Address: 19 Merriam St, Peats Island

C-B-L: 085-J-203, 004 & 016
permit # 2014-02962

CHECK-LIST AGAINST ZONING ORDINANCE

Proposed Use/Work - rebuild home after fire - footprint 32' ^{78'} ~~9 3/8"~~ " x 27', covered porch 8' x 24'
2 story - 20' 8" x 27' near deck 12 x 14
1 story 12' x 27'

DRAWING TITLE: **ELEVATIONS**

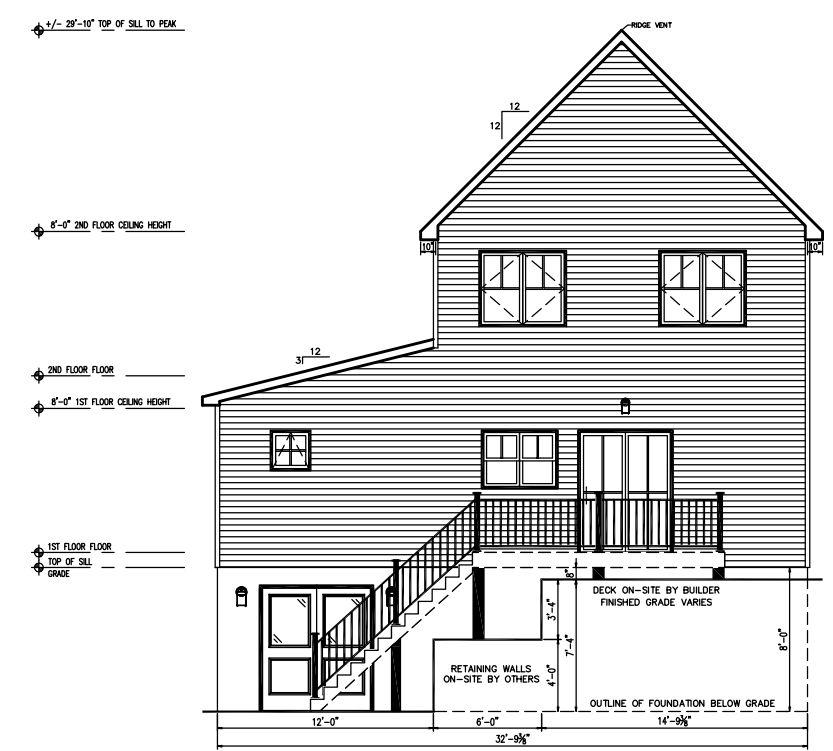
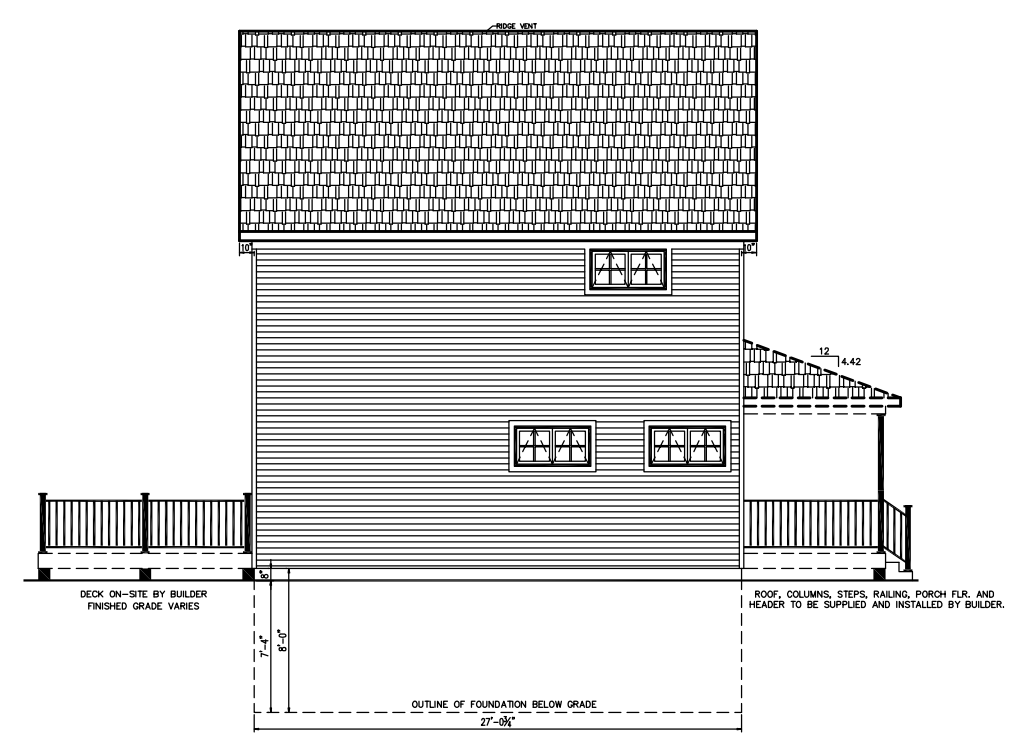
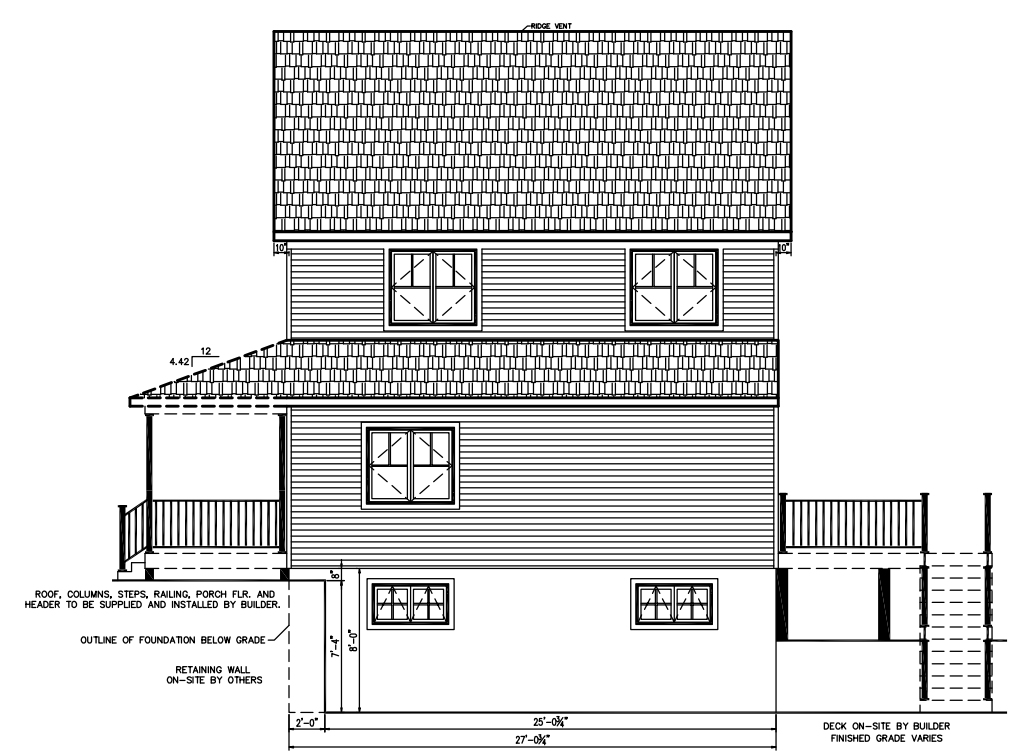
Height - 35' max - 38' to ridge from lowest grade - OK

A2

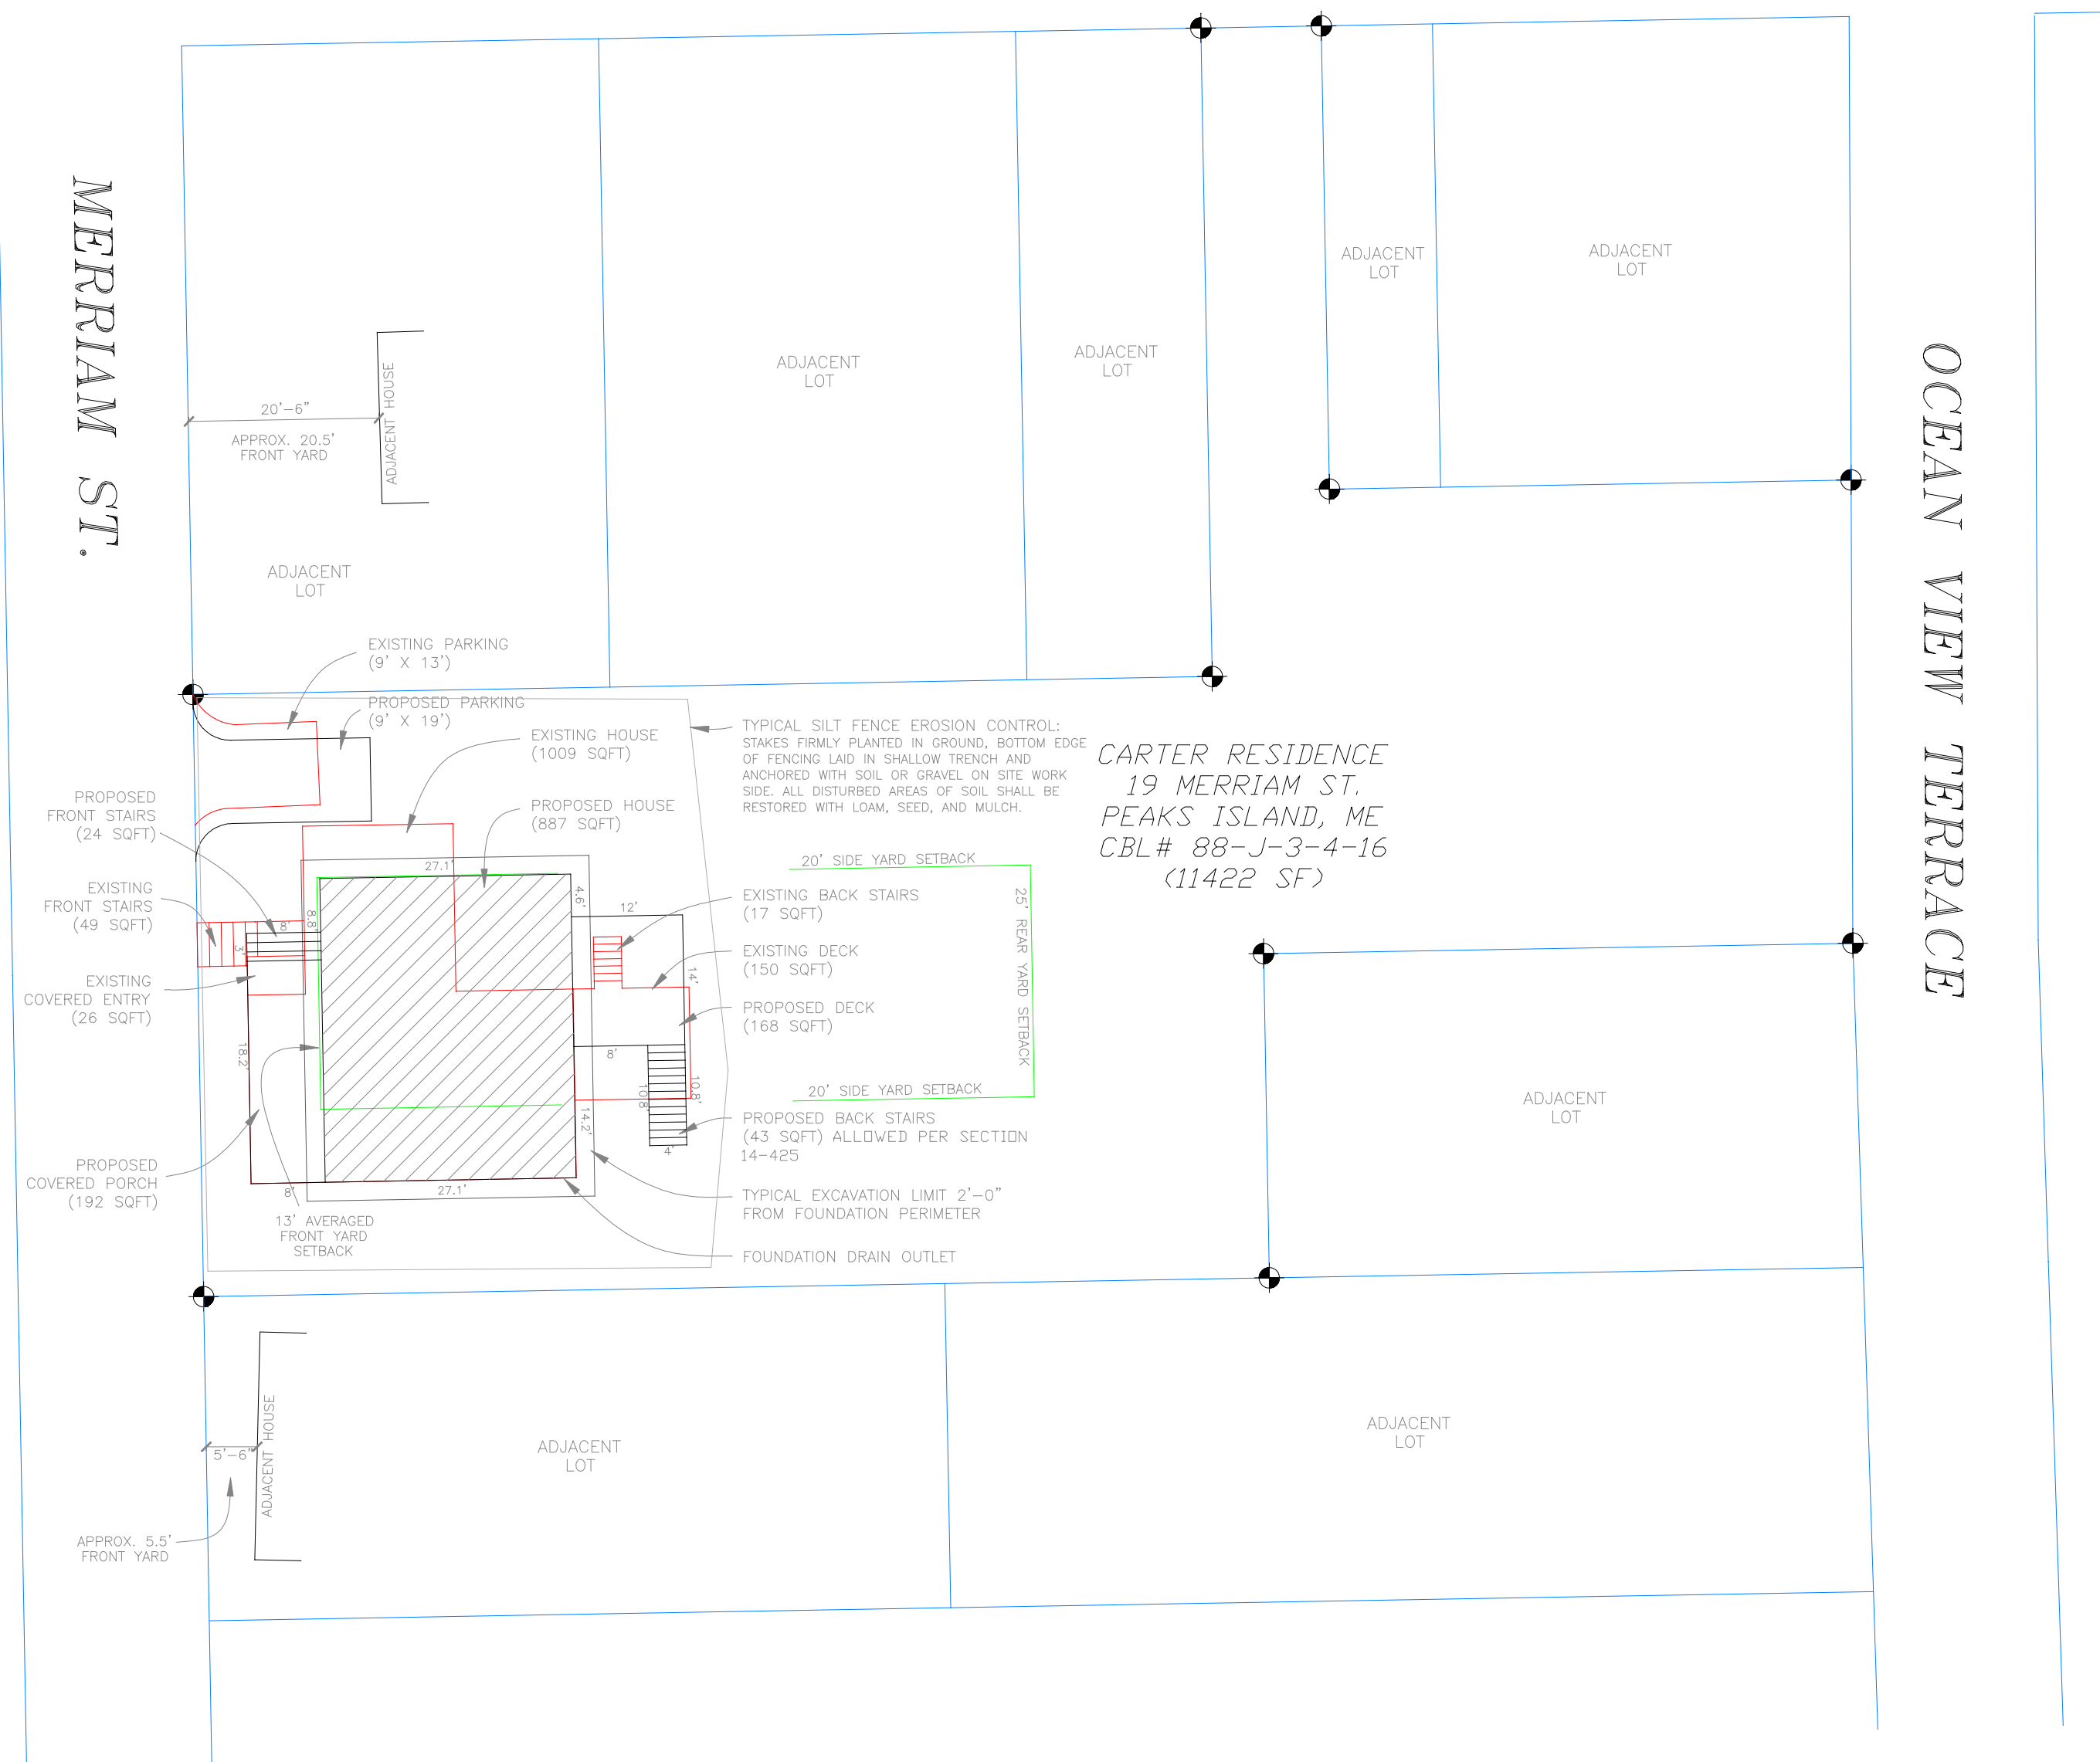
Lot Street Frontage - 70' min. - 65' setback on Merriam ; 13' on Spruce total 78' - rebuilding OK
as developed by

Front Yard - 25' min or average - average is 13' - 8' x 24' encroachment of deck ~~to stairs~~

Rear Yard - 25' min - 62.5' setback OK
OK - part of previous footprint
existing stairs - 25' ϕ
proposed " 33' ϕ

Side Yard - 20' min - 20 on left shown
8' max 35' encroachment on right - OK - previous footprint.

Off-street Parking - 2 spaces - 1 parking space existed - 1 parking space proposed - OK

32.78 x 27 =	885.01
8 x 24 =	192
12 x 14 =	168
stairs 4 x 10.83 =	43.32
" 8.5 x 4 =	34
OK.	<u>1322.38</u>
